Our Ref: FG/79/17/HH
Your Ref:

Town & Country Planning Act 1990 (as amended)
Town & country Planning (Development Management Procedure) (England) Order 2015
Application for Planning Permission for Works or Extension to a Dwelling

Development Retrospective application for rear extension and garage conversion
Location 4 Ferring Marine Ferring

BLOCK PLAN.

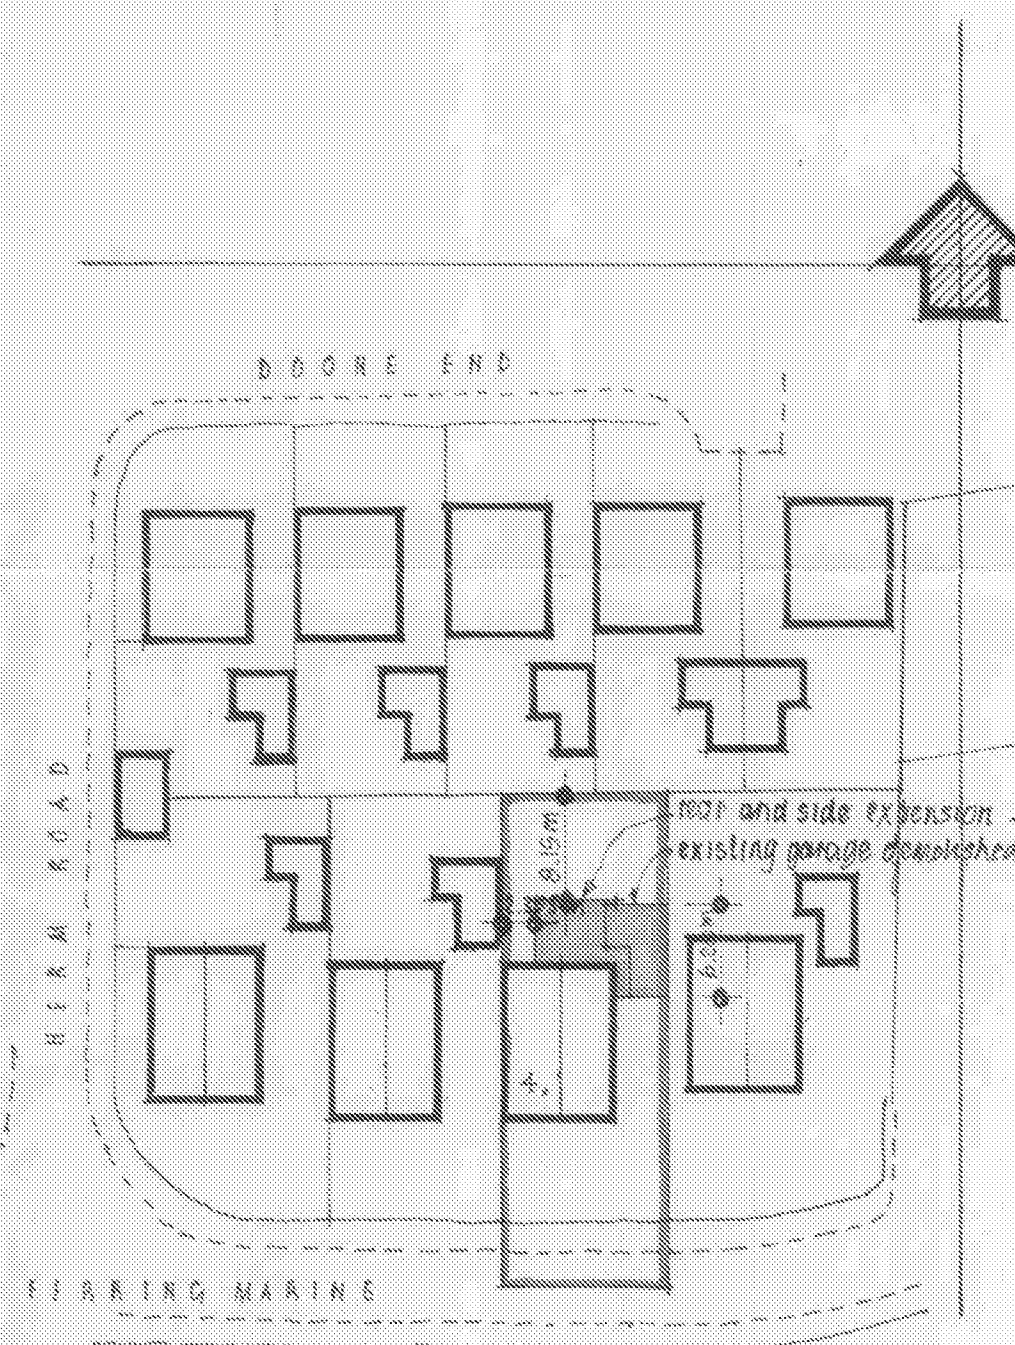
Block Plan

Please annotate the dimensions from the proposed extension to the site boundary.
